Attachment A – Response to Submissions Table

Issues Raised	Proponent's Response
Campbelltown City Council	Council's concerns in relation to the proposal are as follows:	
	Traffic issues <i>Access</i> The road layout within the hospital should be designed in a way that would encourage staff and the majority of visitors to leave the site via the internal road network exiting the precinct through Central Road, rather than via Parkside Crescent. One-way aisles should be implemented in certain locations to prevent the majority of vehicles from egressing the site via Parkside Crescent.	Traffic and Parking issues are addressed in detail in TTW's Response to Traffic and Parking Report at Appendix C. In summary, this issue is not relevant to the proposal, as the internal road layout of the Hospital was rearranged and approved under the REF approval.
	The traffic and parking report submitted with the application indicates that Parkside Crescent has sufficient vehicle movement capacity to absorb predicted impacts (based on RTA guidelines). However, due to the narrow width of the road, high parking demand and road geometry, the driveability of the road is reduced and should not (as described

FACADE MATERIALS LEGEND

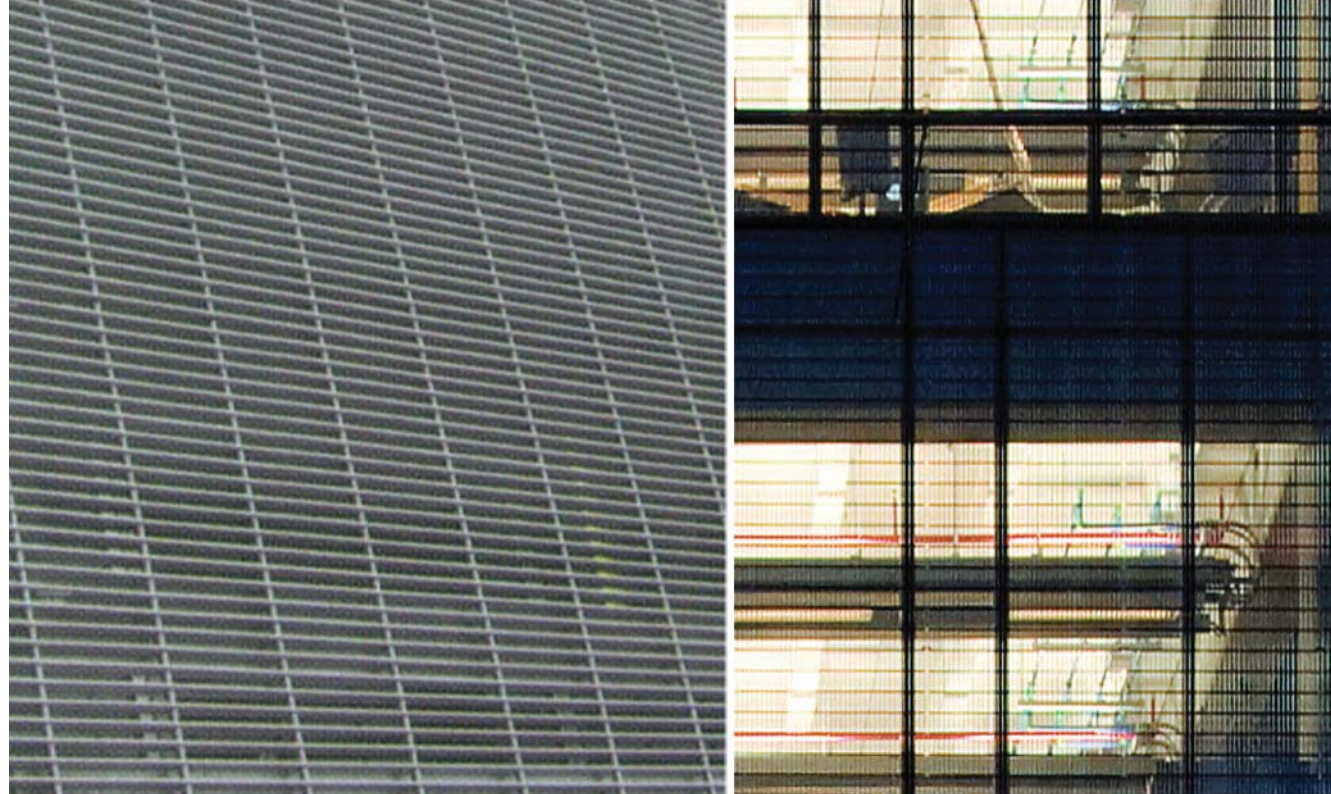
Issues Raised	Proponent's Response
Due to the large areas of concrete proposed at street level, the development does not interact positively with the street domain and presents significant opportunity for graffiti attack. Although the ground level of the building and retaining walls would be partially screened by landscaping, the urban design outcome is not satisfactory. Landscaping should not be relied upon to screen an unsatisfactory design.	The updated plans at Attachment B replace the precast wall to the base of the building with infill stone gabion wall infill panels. The gabion wall will provide a more attractive wall feature as well as naturally deterring graffiti and will reflect and complement the stone surrounding to the Birunji Creek to the park opposite, effectively connecting the base of the building with park surrounds. Further detail is provided within Section 2.1 of this Response to Submissions Report.

- The following amendments need be made to enhance the quality of the architectural outcome, and to ensure the development does not detract, but adds value to the character of the precinct and the Campbelltown Regional City Precinct: - Glazed windows or alternative architectural devices need to be provided at street level on the building's western facade. - The protruding stair towers require improved design and architectural treatment including articulation, additional glass and/or alternative/supplementary materials and/or colours - The building's roof should be redesigned to achieve an improved visual interest. - The change in ground levels between the street and the area north of the proposed hospital building requires a better solution than a large bland retaining wall. A landscaped slope or	Refer to above for comment and Section 2.1 of this Response to Submission Report for further detail and design amendments.
